City of Albuquerque

September 20, 2000

**RE: IRON MOUNTAIN STORAGE FACILITY, MERIDIAN BUSINESS PARK (J10-D30).
ENGINEER'S CERTIFICATION FOR CERTIFICATE OF OCCUPANCY APPROVAL.
ENGINEER'S STAMP DATED SEPTEMBER 14, 2000.**

SHEET  
C-1

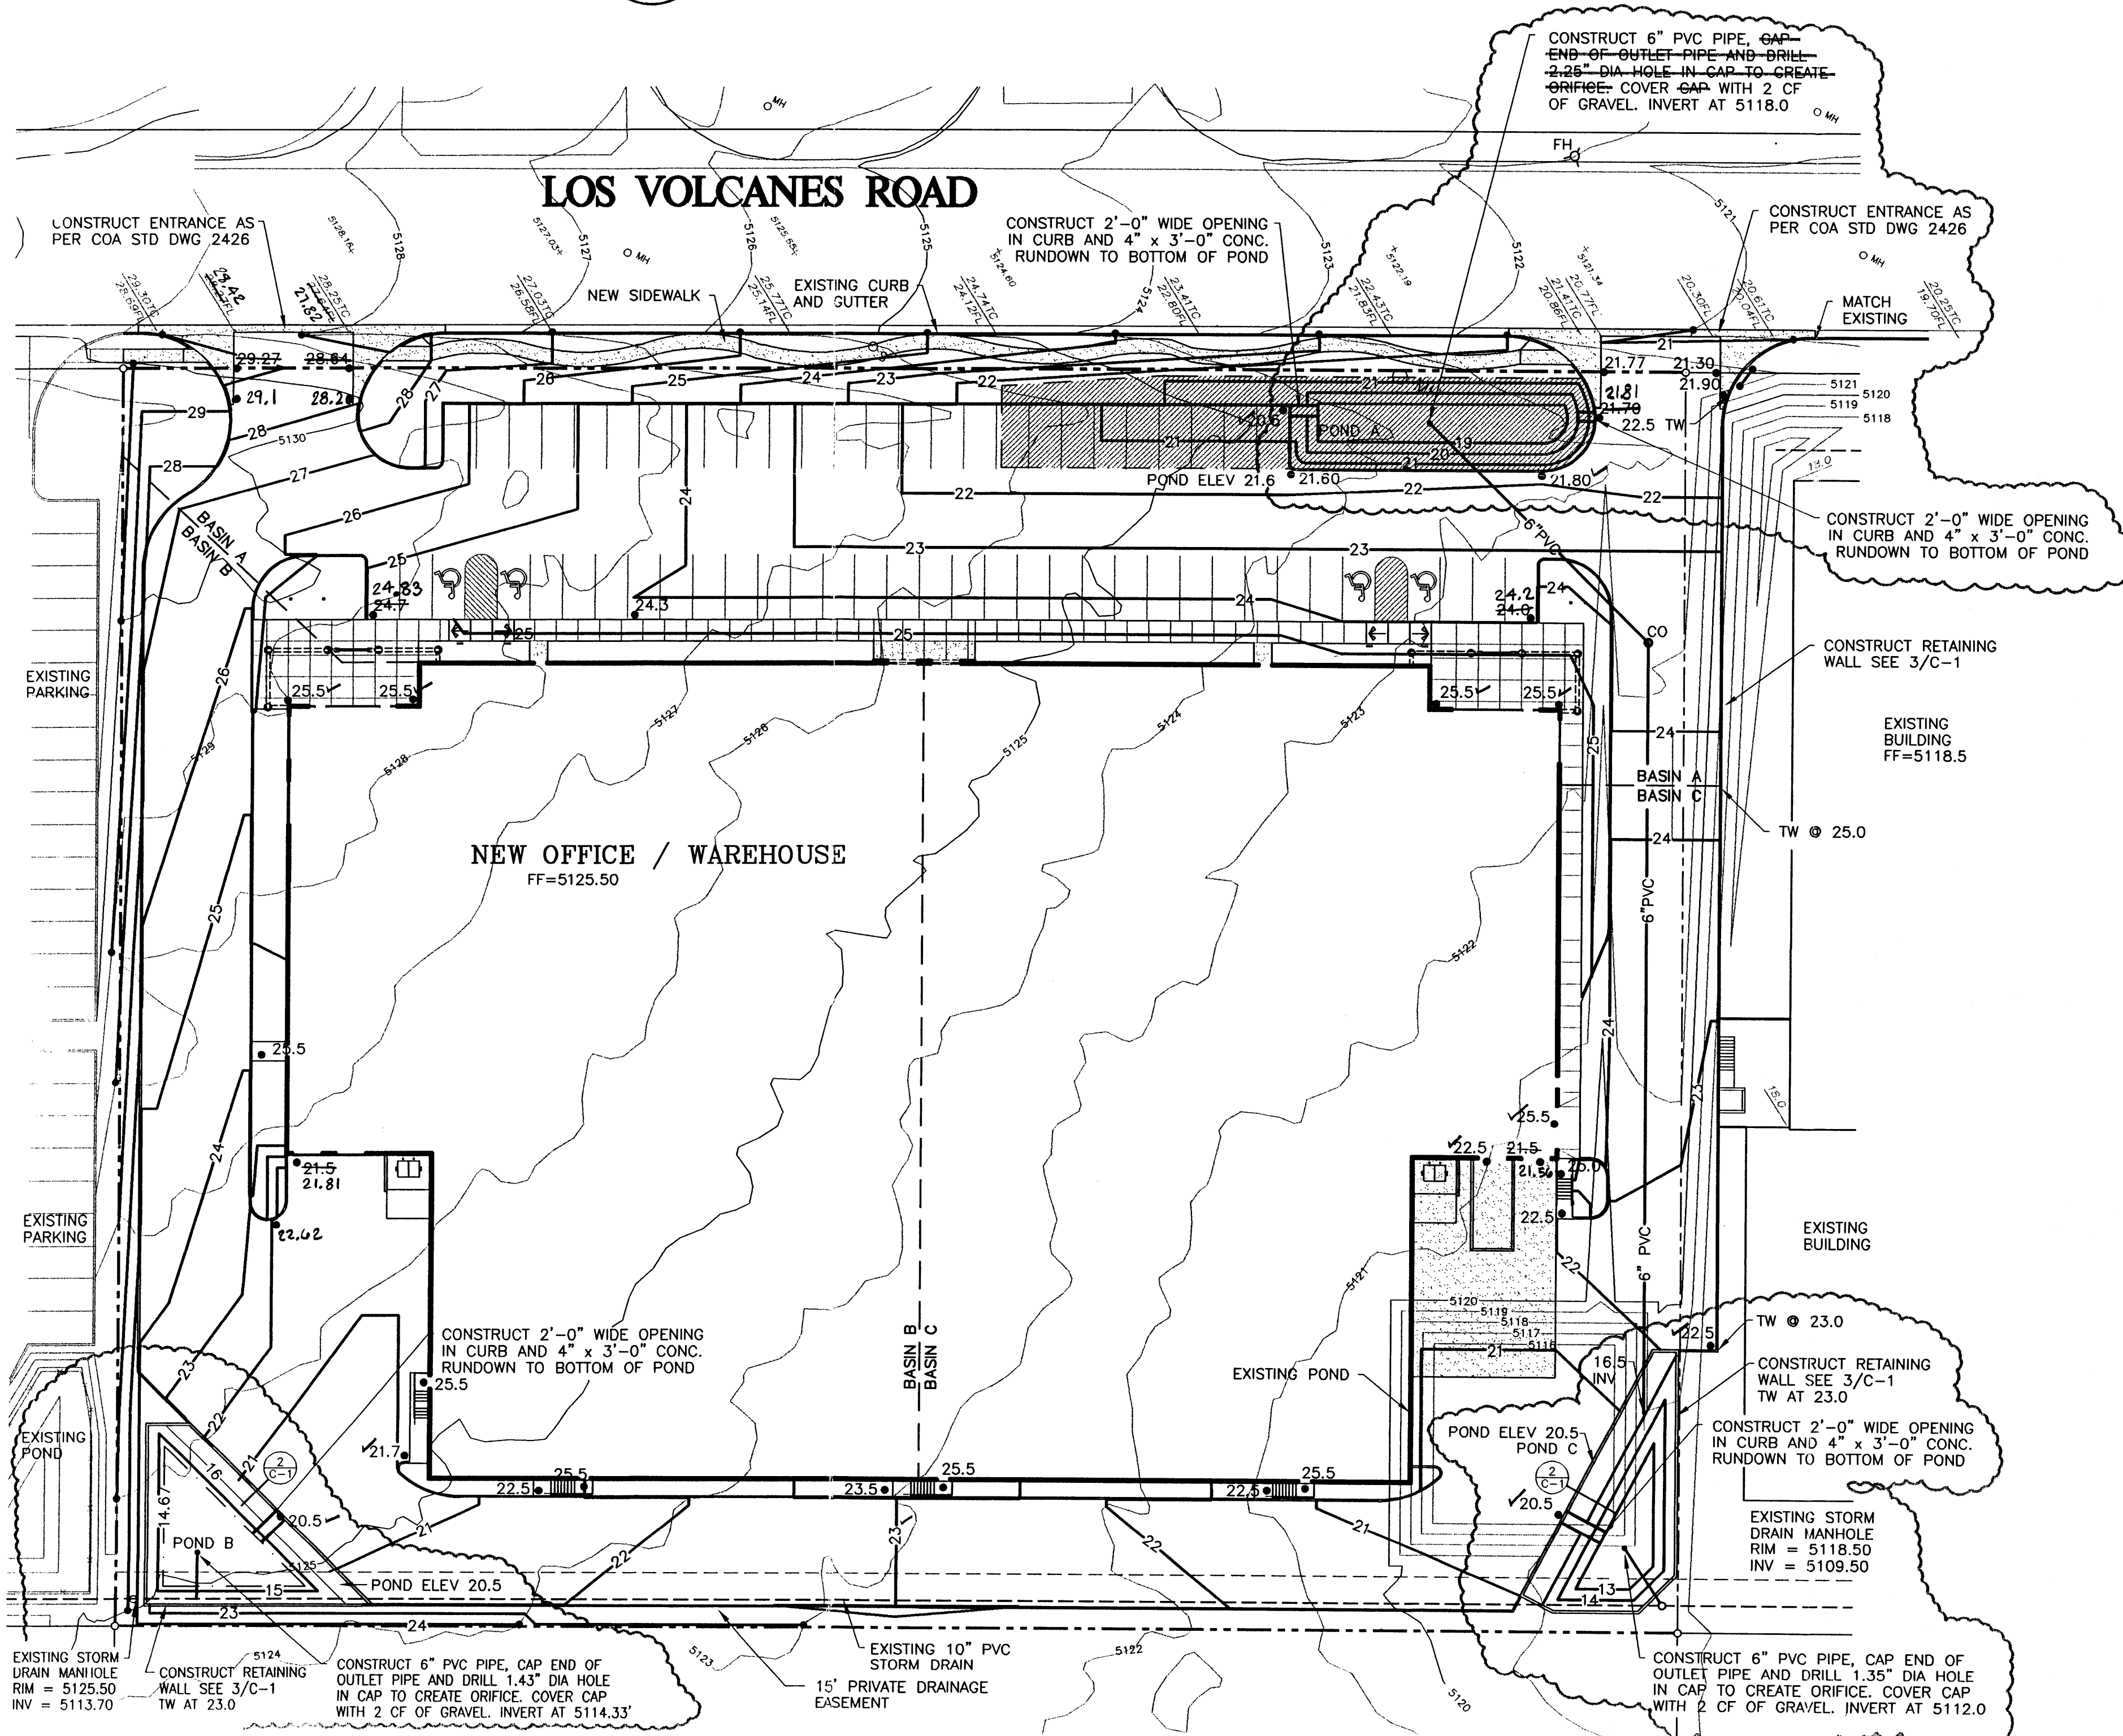
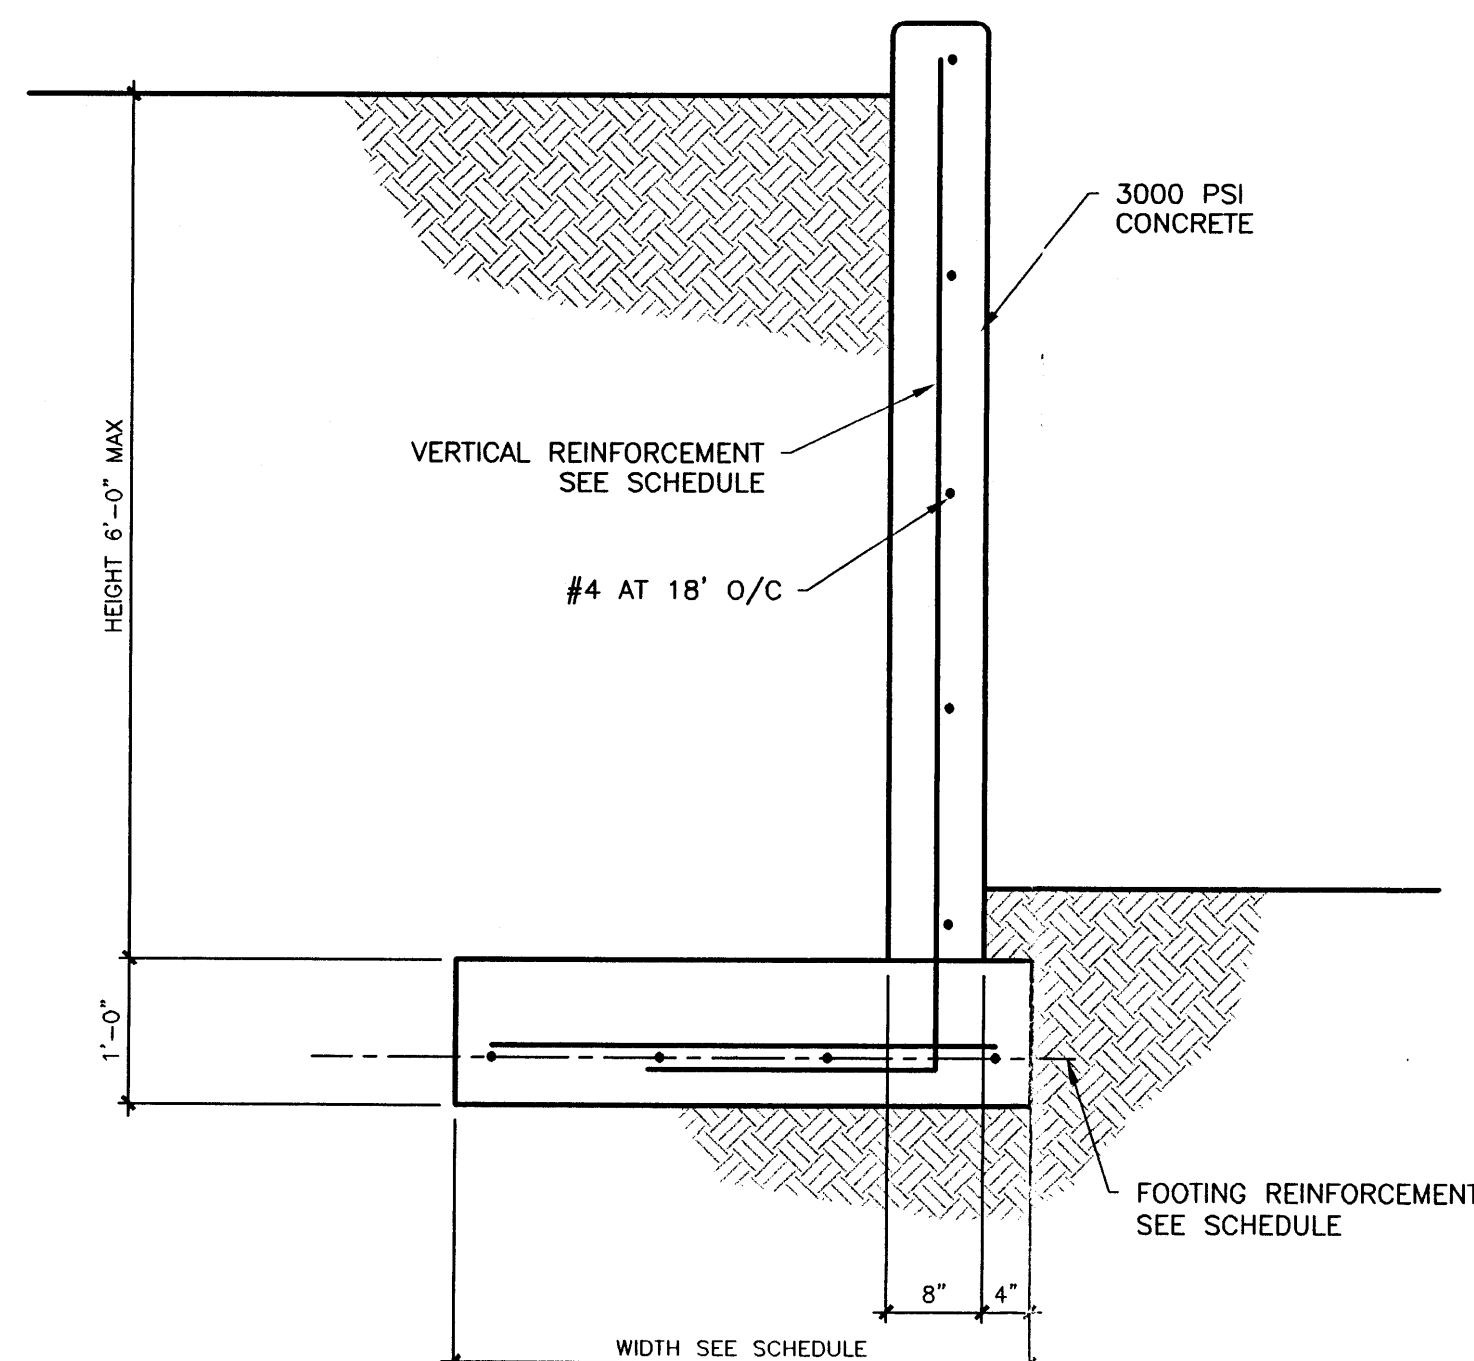
A detail of the orifice outlet would be desirable. Since they are an operational and maintenance problem, diameters to the hundredth inch are not all that practical. It is not evident that the new and existing storm drain lines will be clear of the new construction - ponds, retaining walls.

Attached is the Drainage Information Sheet and our Grading and Drainage Certification for permanent Certificate of Occupancy for the referenced project. All of the grading and drainage items are complete. Modification to the ponds where required due to the elevation of the existing private storm drain along the south property line. The attached plan reflect these changes.
